Application No: FP/3/25/HH
Site Address: 7 Second Avenue Felpham PO22 7LJ
Description of works: Proposed timber shed and front garden fence.

Thank you for your internet representation made on 25th January 2025 which has been recorded as an objection with the comments as follows:

Drawing:
**Shed
Plan As Existing & Proposed**

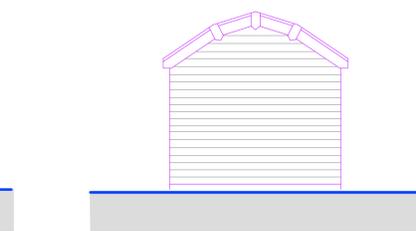
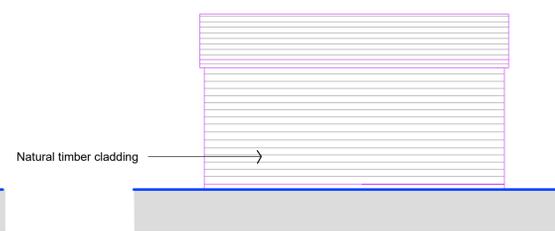
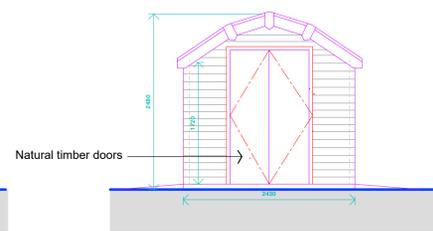
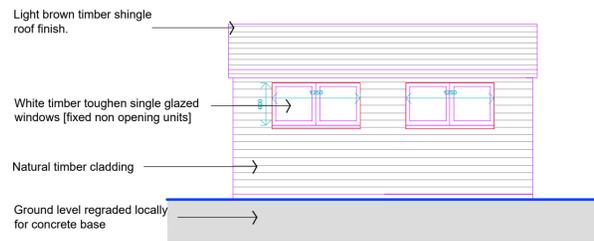
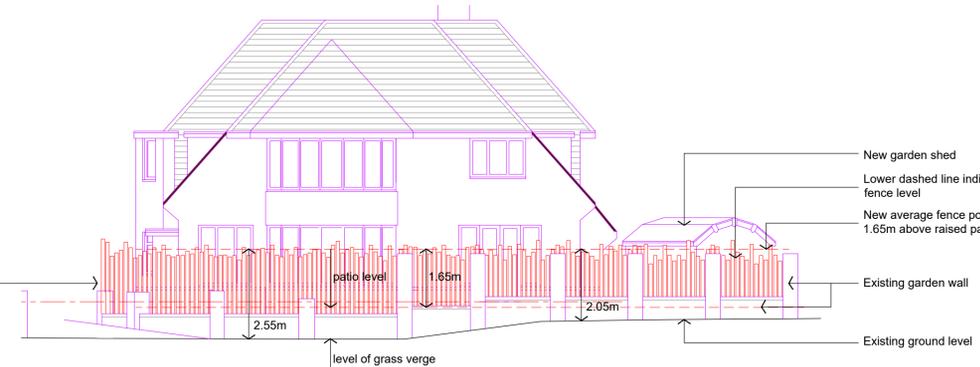
We ask that the location of the shed/summer house be reconsidered.

The side of our property (the main part of the house) sits along the twitten of Second Avenue, and the window in the family area off the kitchen looks side on to the front garden of Summerley House, as does our lounge bay window.

A structure of that size situated in the proposed location at the front of the property, would without doubt, reduce light coming into our kitchen family area, and would be an unsightly intrusion in terms of the view.
